**Consultation Response from KC,
 Conservation and Design**
2020/94203 Clough House, 236, Leeds Road, Birstall, Batley, WF17 0HW
Outline application for demolition of dwelling and associated outbuildings and the erection of 30 dwellings
Date Responded: 08.1.2021
Responding Officer: NG
Responding Ref:
1. Summary.

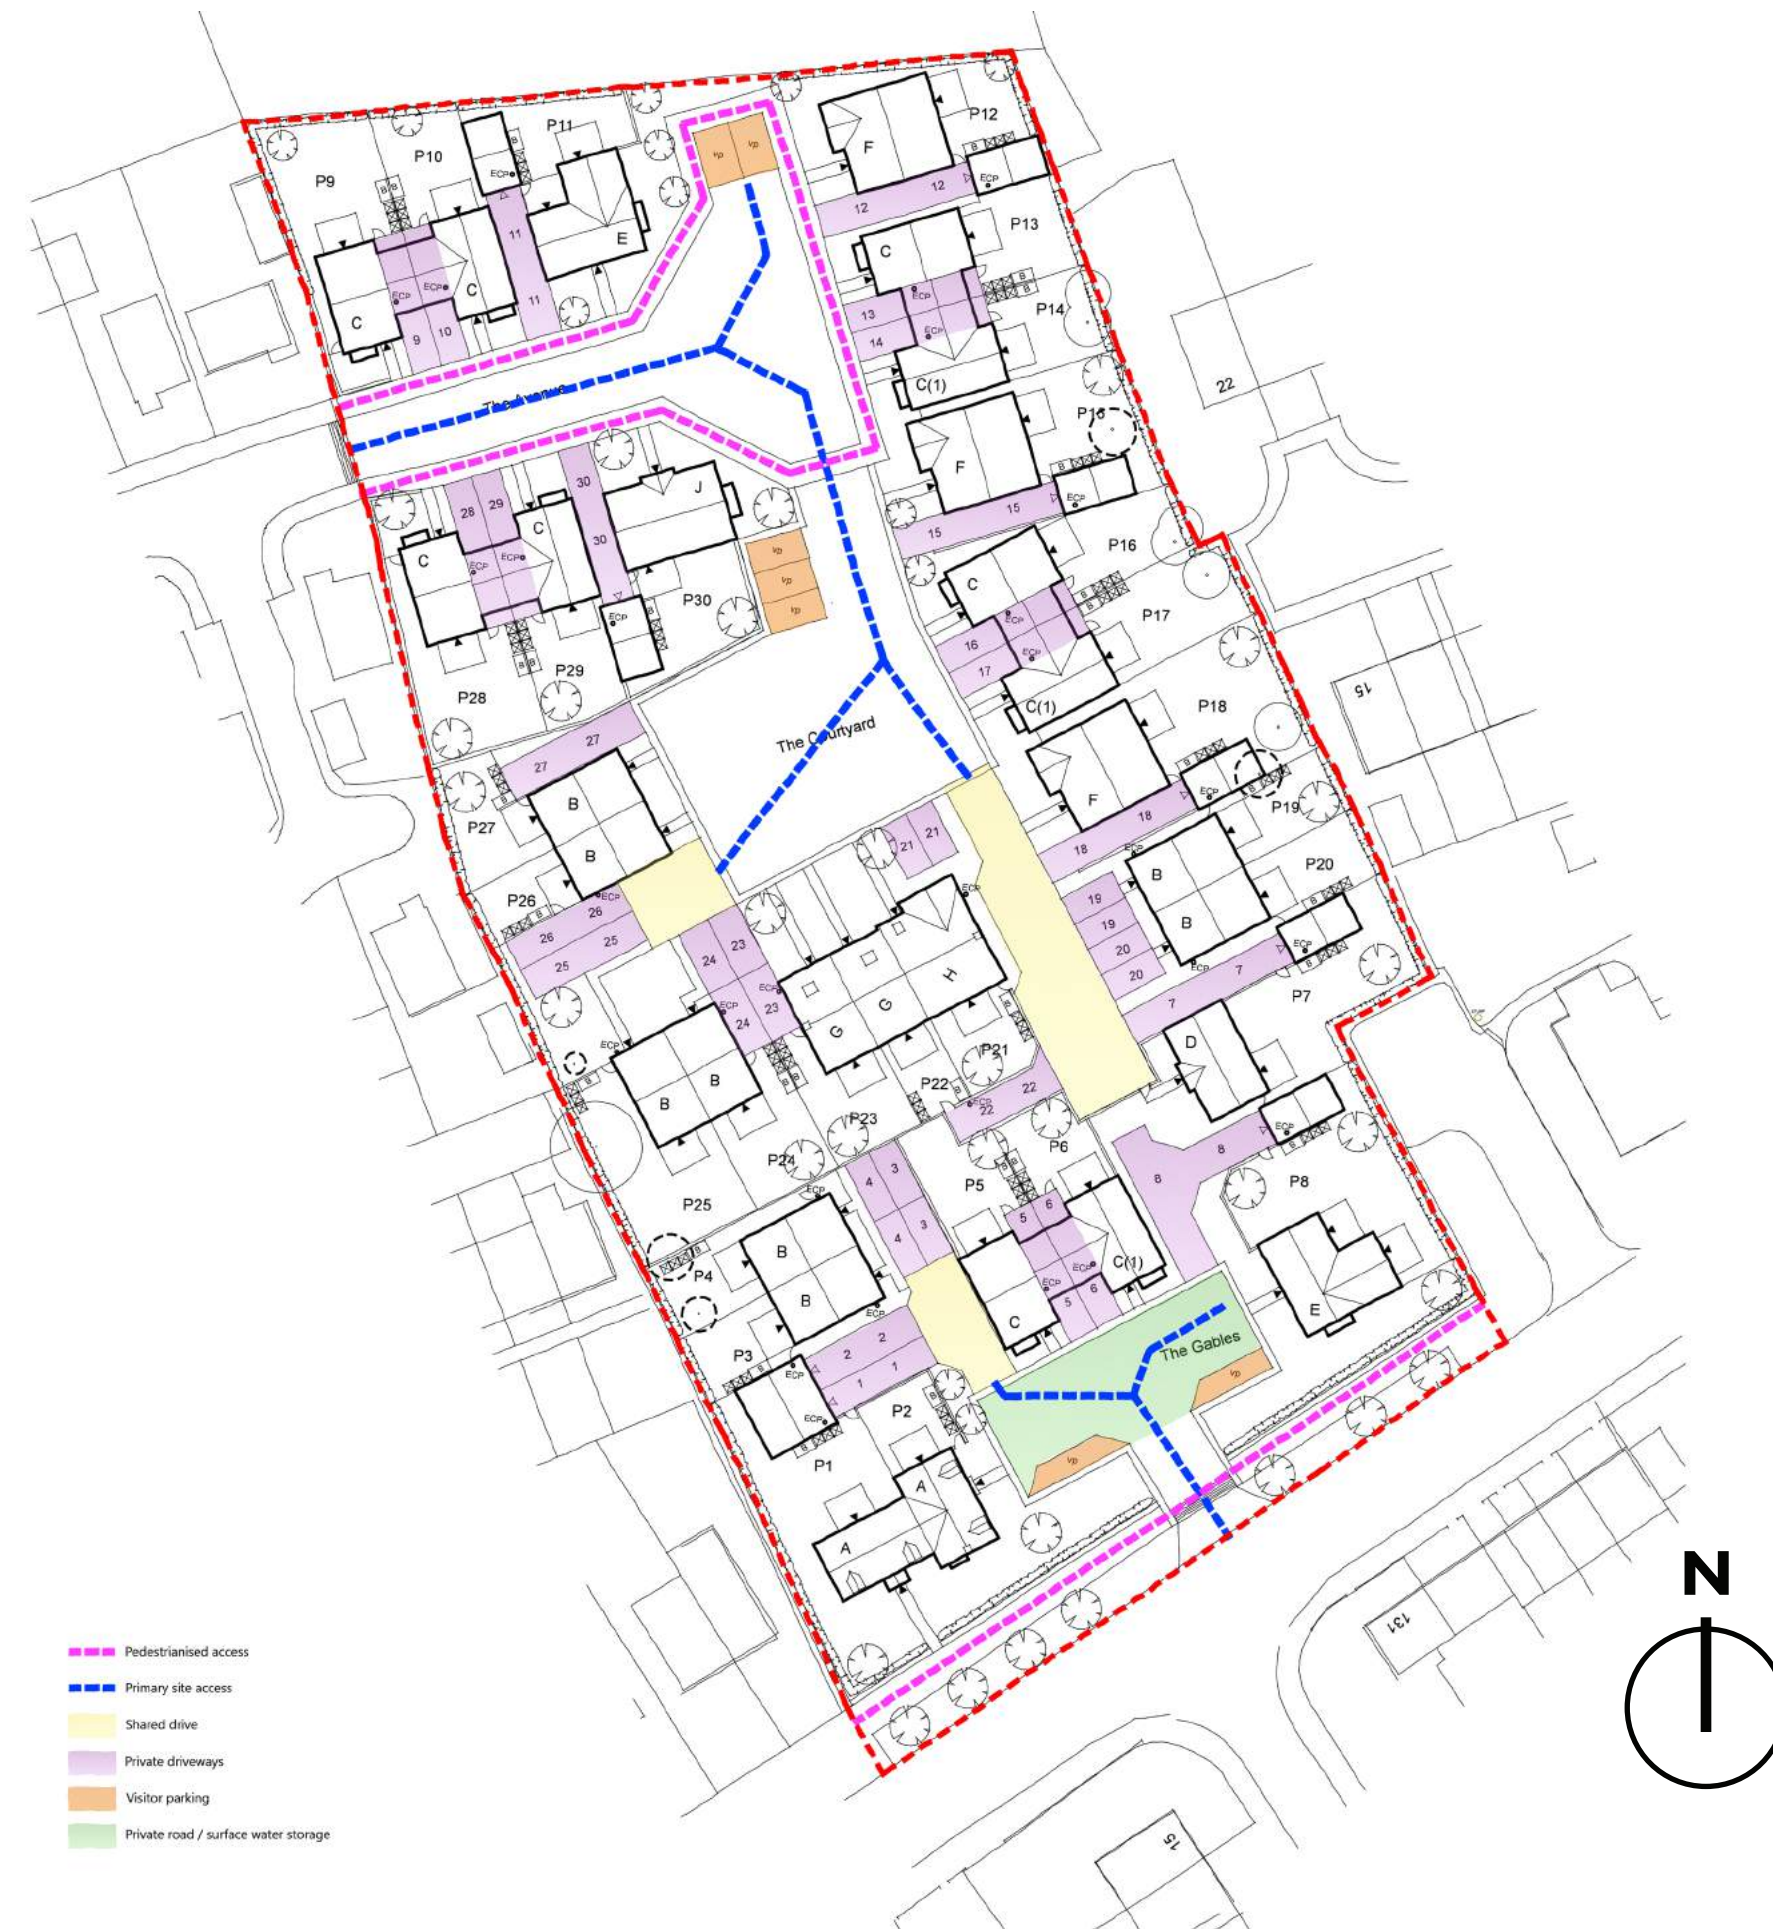
The current outline proposals present a form of development which results in the complete loss of the surviving historic features and presents a residential layout which is characterised by extensive areas of hard-standing surfaces and is focused on the accommodation of vehicle movement and parking. The proposed residential units are tightly packed with minimum amenity space, no green space or streetscape planting and no space for the accommodation of biodiversity. The proposal thus presents a **high level of harm** to significant local heritage assets and a **poor residential design** which demonstrably fails to improve the character and urban quality of its context.

The proposal would remove all currently extant boundary features and landscaping and limits pedestrian links across the site. It is worthy of note that the current proposals have been preceded by a series of site works which have removed the mature landscape and boundary features (including the mature boundary trees) as well as many of the internal architectural features of the historic buildings. The result would be an insular, visually sterile and anonymous, collection of cud-de-sacs, with negligible greenspace and inadequate linkages to local amenities or greenspace and no accommodation for wildlife space. The proposals consequently fail to respond to the opportunities to respond positively to their context and contribute little to the creation of a distinctive townscape or the wider character and quality of the locality.

The outlines plan indicates an area of 'open space' at the north end of the site which suggests a connection with the site. However, this area is outside of the redlined area and is designated as industrial land (with a lapsed consent for warehousing) and would remain inaccessible.

Therefore, it is recommended that the proposed development is not supported or granted in this form. The applicants should be advised to fundamentally reconsider their development options for the site, focusing on retaining and integrating the identified, significant heritage assets within an alternative residential development.
